DRB Application No.: 05DRB-00205 (SBP)  
Project Name: ALAMEDA BUSINESS PARK  
Agent: Sanders Associates Architects

February 11, 2005

**CITY OF ALBUQUERQUE  
PLANNING DEPARTMENT  
February 16, 2004  
DRB Comments**

**RE: Lot 42, Alameda Business Park/SPBP**

SITE PLAN FOR BUILDING PERMIT

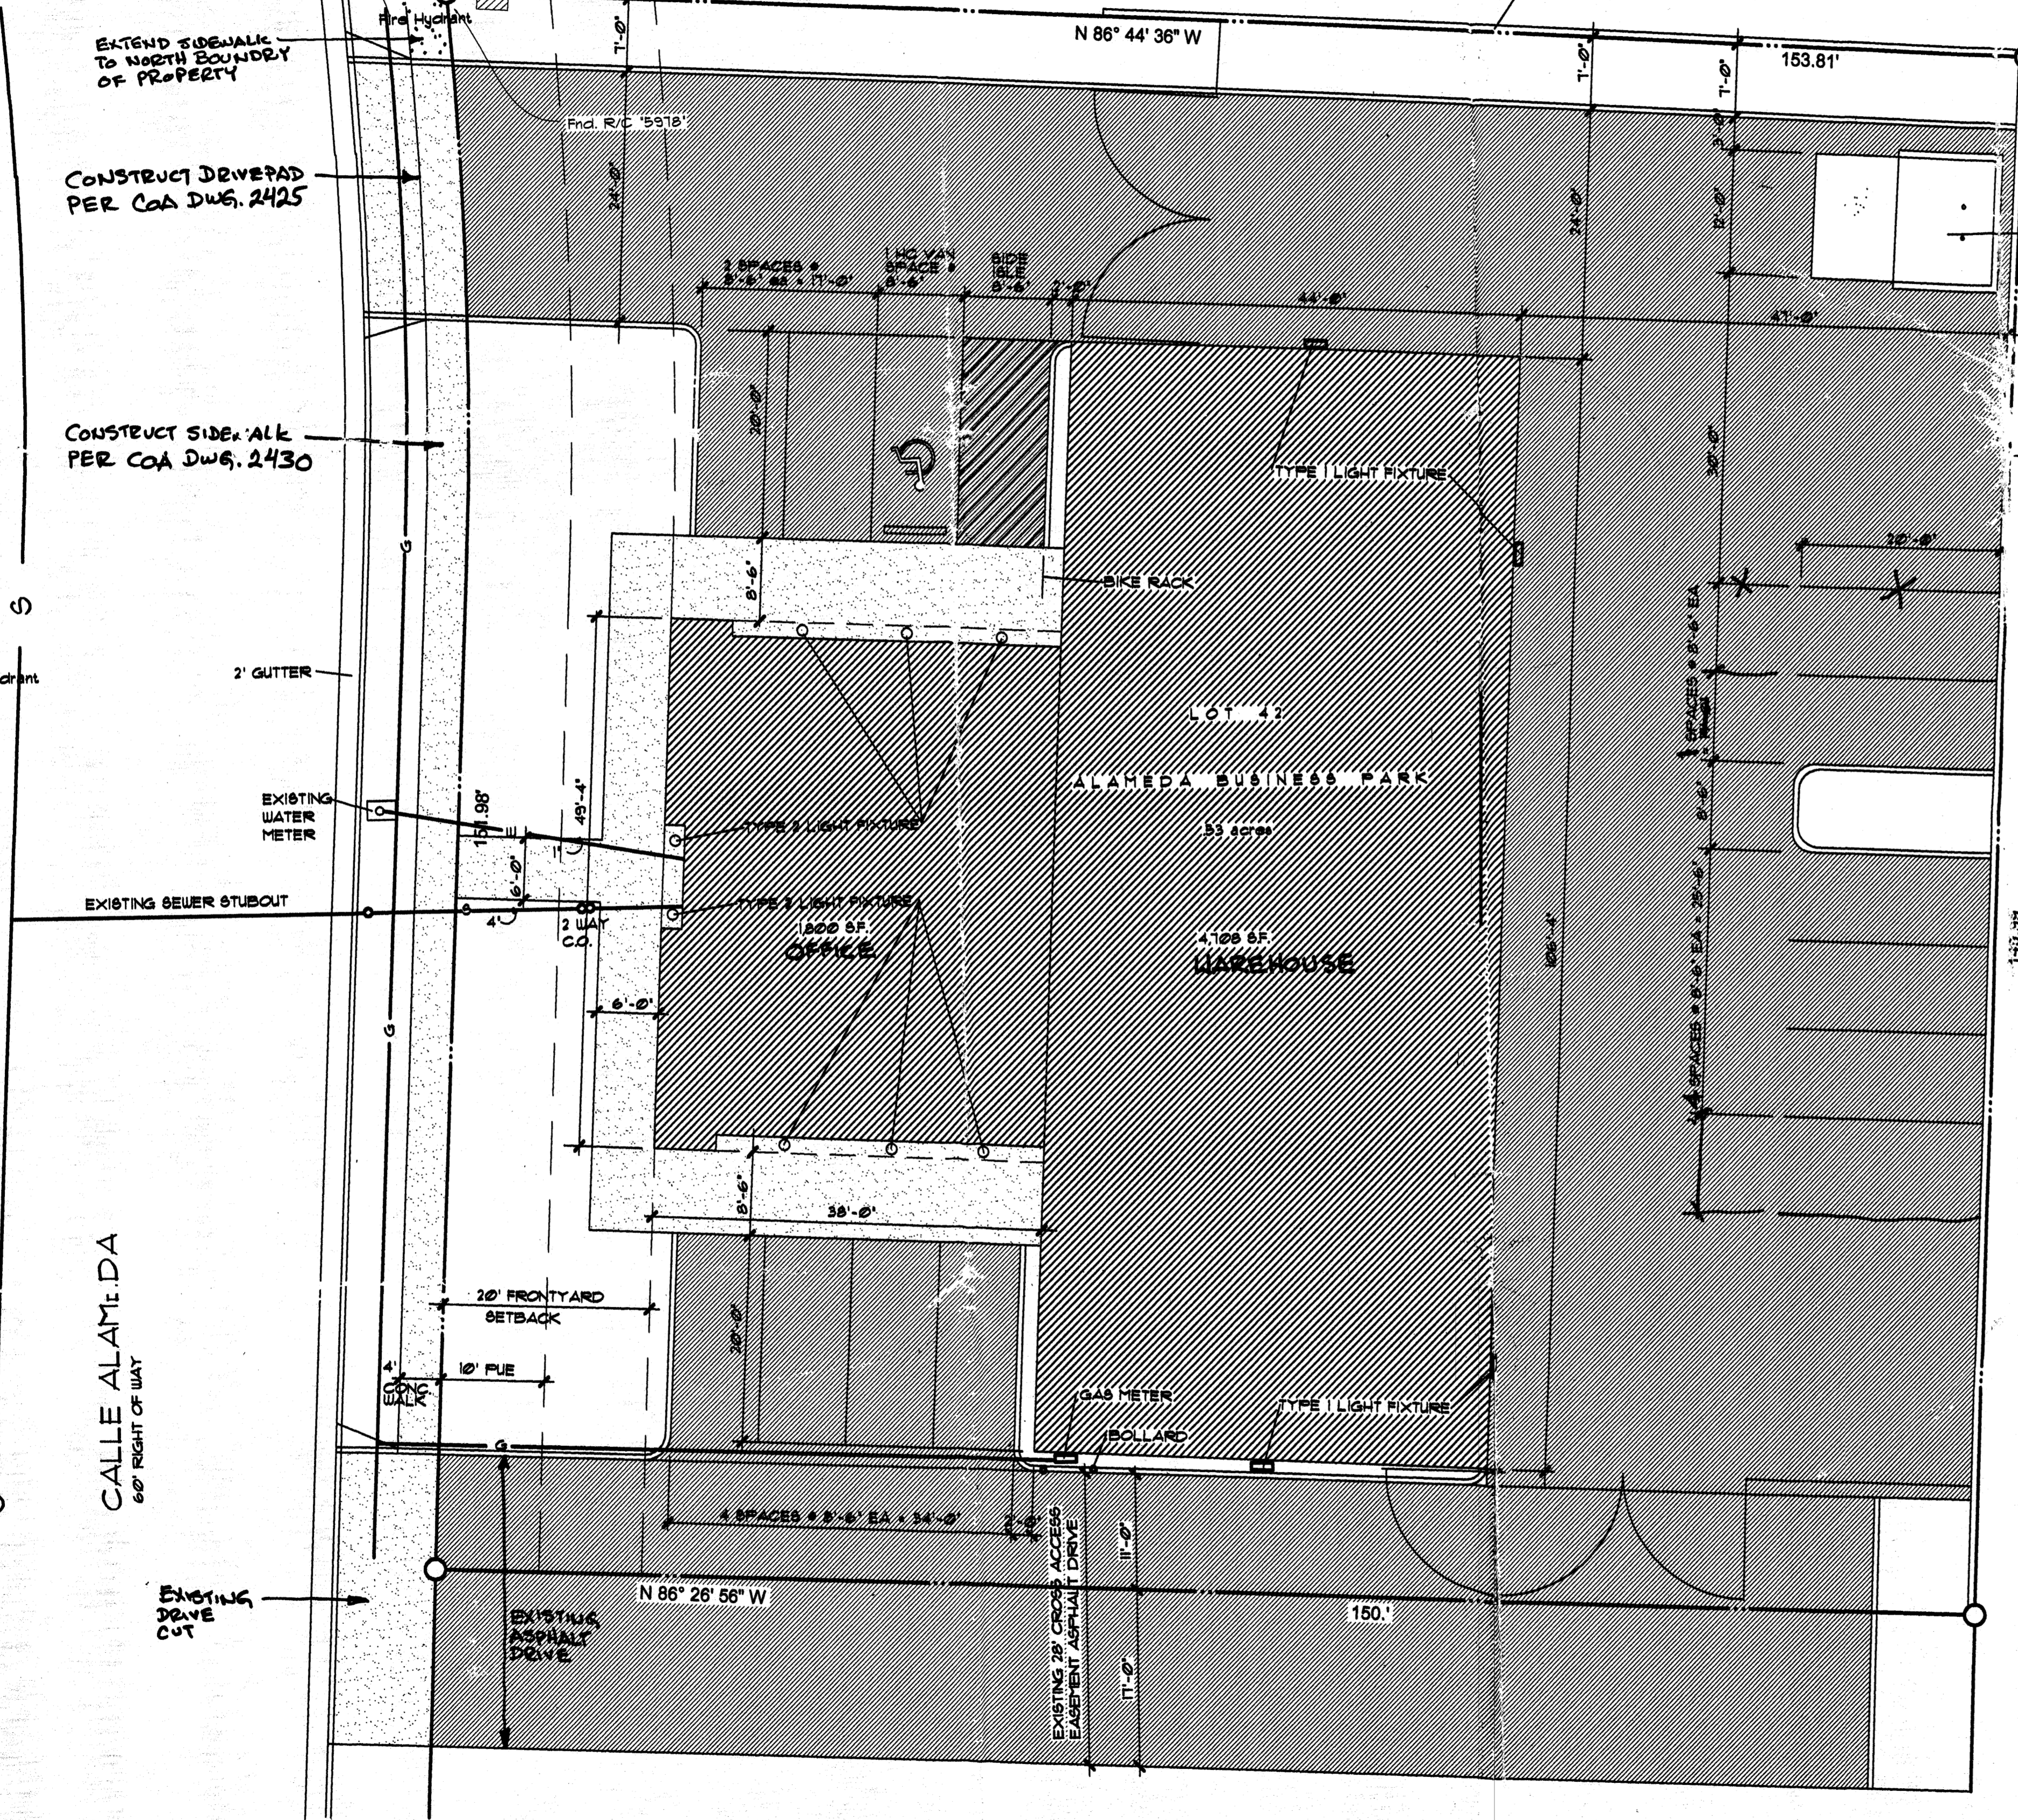
PLANNING (Last to sign): Add roof language on 2/11/05  
letter on to SBP as a note  
DM 2/17/05

1. The signature block is incorrect. Be sure to place the correct one ✓  
on your SPBP original before the DRB meeting. The form is available  
at the One Stop Shop Front Counter.
2. The proposed use is not listed on the building footprint on the Site ✓  
Plan sheet. *no 25' x 40'*
3. There are no signs shown on the SPBP. Why? *none*
4. Why is the Loading Facility on the checklist marked "NA" when ✓  
there is a loading facility at the rear of the building? *no loading dock*
5. Is there any lighting in the parking lot? None is shown. *no*  
*boundary must fall*
6. The dumpster enclosure elevation should be placed on one of the ✓  
sheets in the SPBP.
7. On Sheet C-2, please place the title by the "Landscape Plan" by ✓  
the C-2.

1. The signature block has been revised to match the City standard.
2. The proposed use of Office and Warehouse has been added on the building footprint.
3. There is no building signage proposed per the property owner's direction.
4. There is no loading dock the overhead doors on the east side of the building are drive in doors.
5. Lighting is mounted on the building and there are to be no pole mounted lights. All lighting will be shielded per the note on sheet C-1.
6. The dumpster enclosure elevation has been placed on sheet C-1.
7. "Landscaping Plan" has been added next to C-2.

The roof for the office has a parapet which shields view of both the roof and all mechanical equipment. The warehouse portion has a pre-finished ribbed metal roof which shall not have a highly reflective surface per requirements of the Alameda Business Park Master Plan.

Project no. 0429  
 sheet  
**C-2**  
 of  
 2-03-05

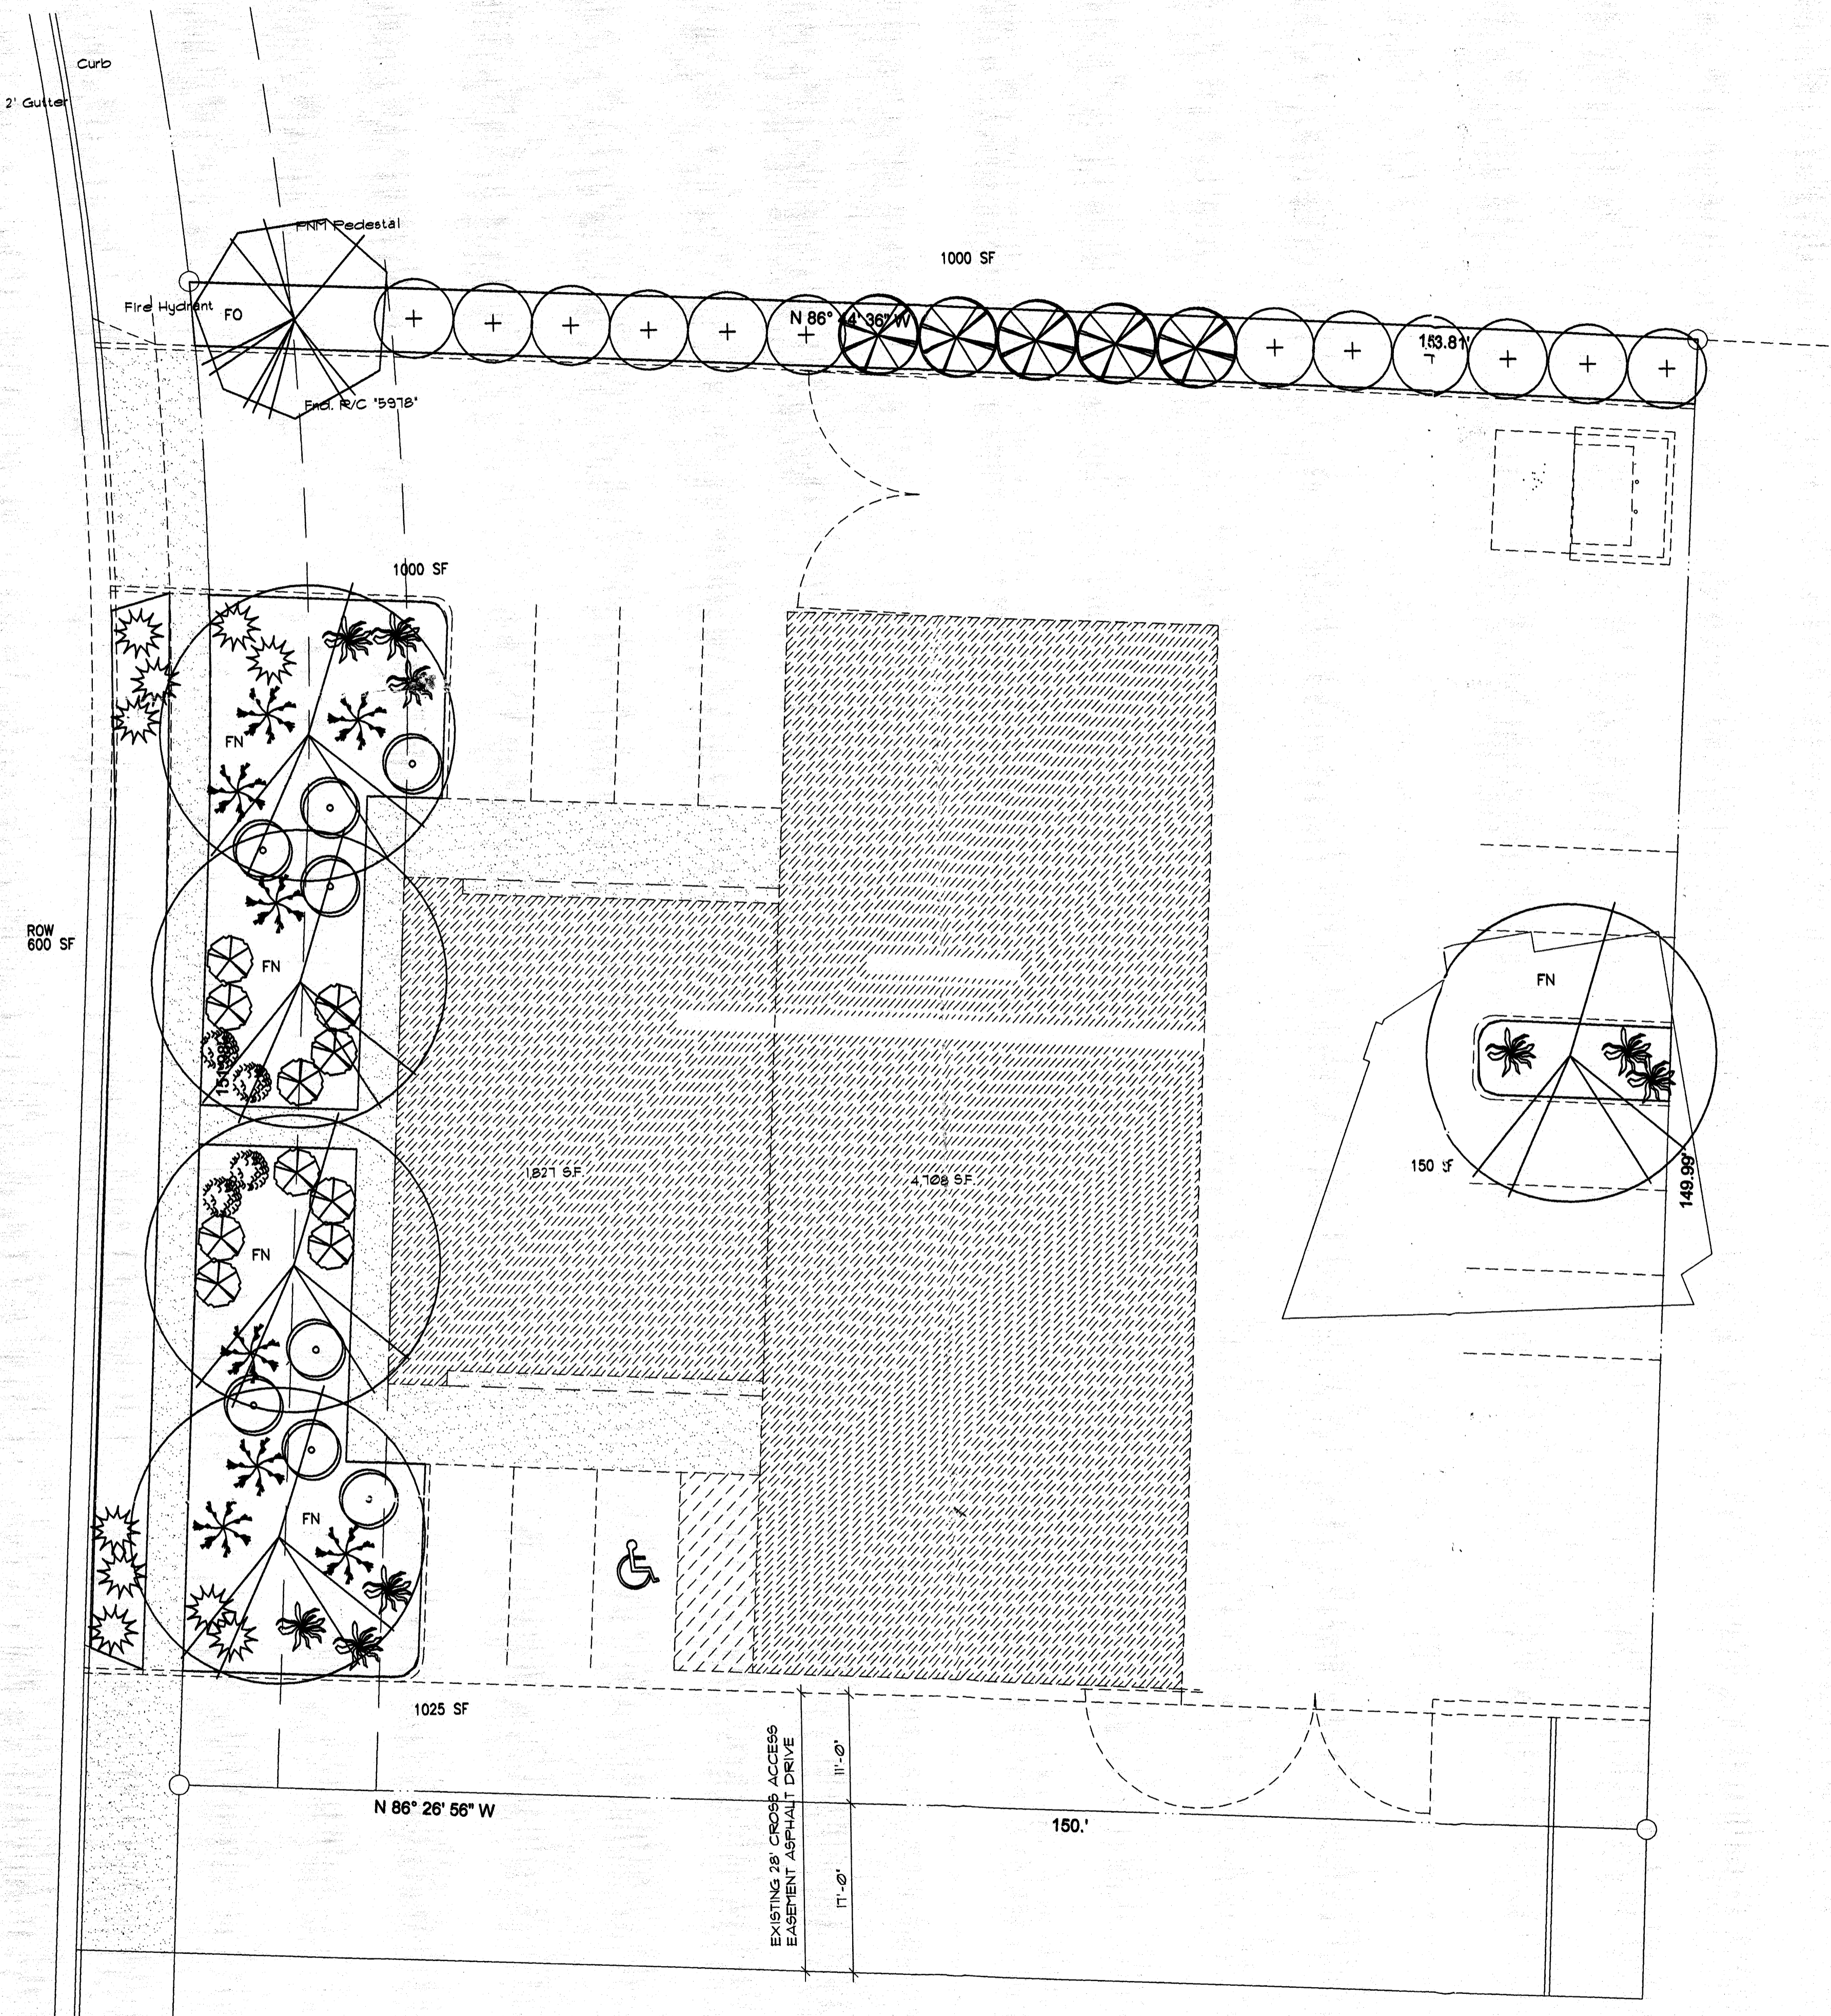
- \* 1. Per the North I25 Sector Plan;
  - The required 6' rear yard landscape buffer is missing.
  - Both this plan & the Alameda Business Park Master Plan require all parking spaces to be no more than 50' ~~from~~ <sup>from</sup> a tree. The SPBP states 100'.
- 2. Per the Alameda Business Park Master Plan:
  - The gravel in the Landscape Plan should have color. The Alameda Business Park Master Plan requires Santa Ana Tan gravel. Santa Fe Brown is an acceptable substitute.
  - Look at Amendment 2, #5, Roofs and include what is required by this amendment in the SPBP.

1. It is our understanding that the required North I25 rear yard landscape buffer will not be required because the rear of the site is walled and thus screened from view. Jack Basye has indicated that they rear landscaping buffer may be omitted in a note that is attached.

The note on the landscaping plan has been corrected concerning the requirement that no parking space be farther that 50' from a tree. The landscaping plan reflects no parking space is further than 50' from a tree.

2. A note has been added to the landscaping plan that the gravel shall be Santa Ana Tan.

*\* The rear landscaping buffer may be omitted for lot relationships within this larger site development plan, the Alameda Business Park. Jack Payne 2/11/05*
